KITTITAS COUNTY FIRE MARSHAL'S OFFICE

July 8, 2016

Re: Bivens (BL-16-00008)

**PART OF THE NORTHEAST QUARTER OF SECTION 31,
TOWNSHIP 18 NORTH, RANGE 19 EAST, W.M.**

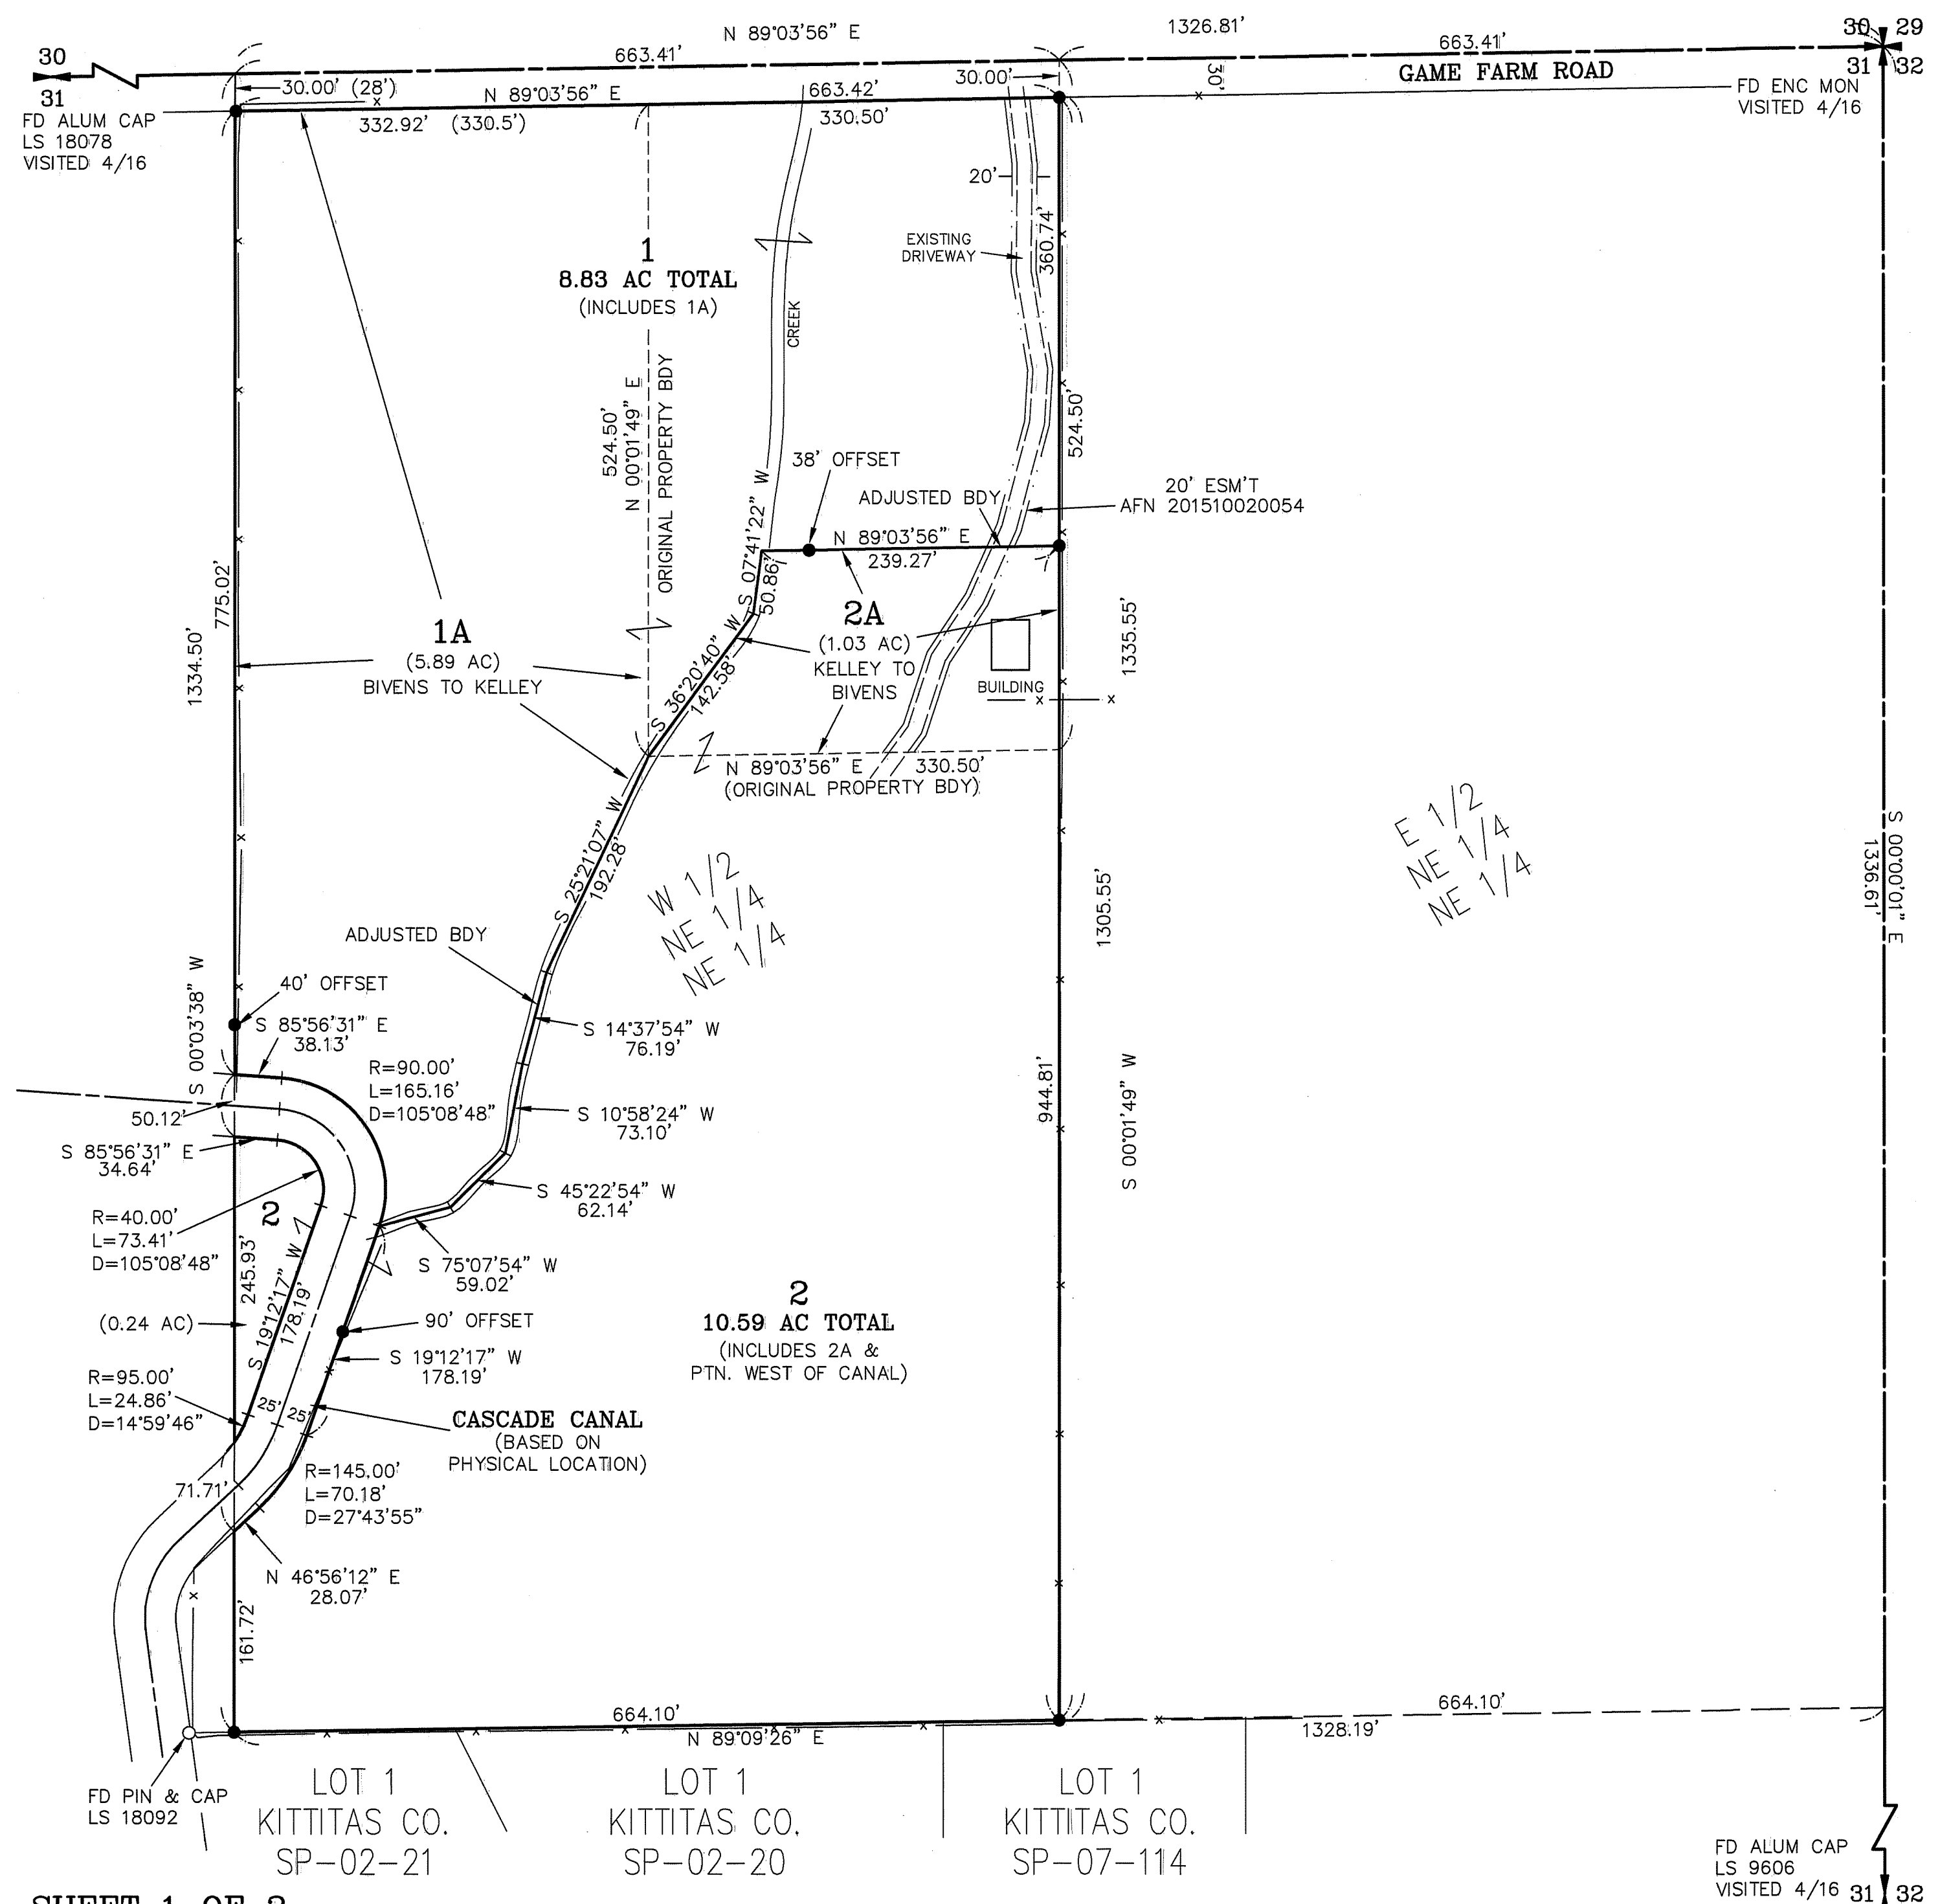
- Ensure that boundary line adjustments do not infringe upon existing structures, to include propane tanks, etc.
- Ensure adequate access for fire apparatus. Any driveways or access points created based off the new lot configurations shall comply with Kittitas County Code 20.02.030.
- All future development must comply with the International Fire Code.
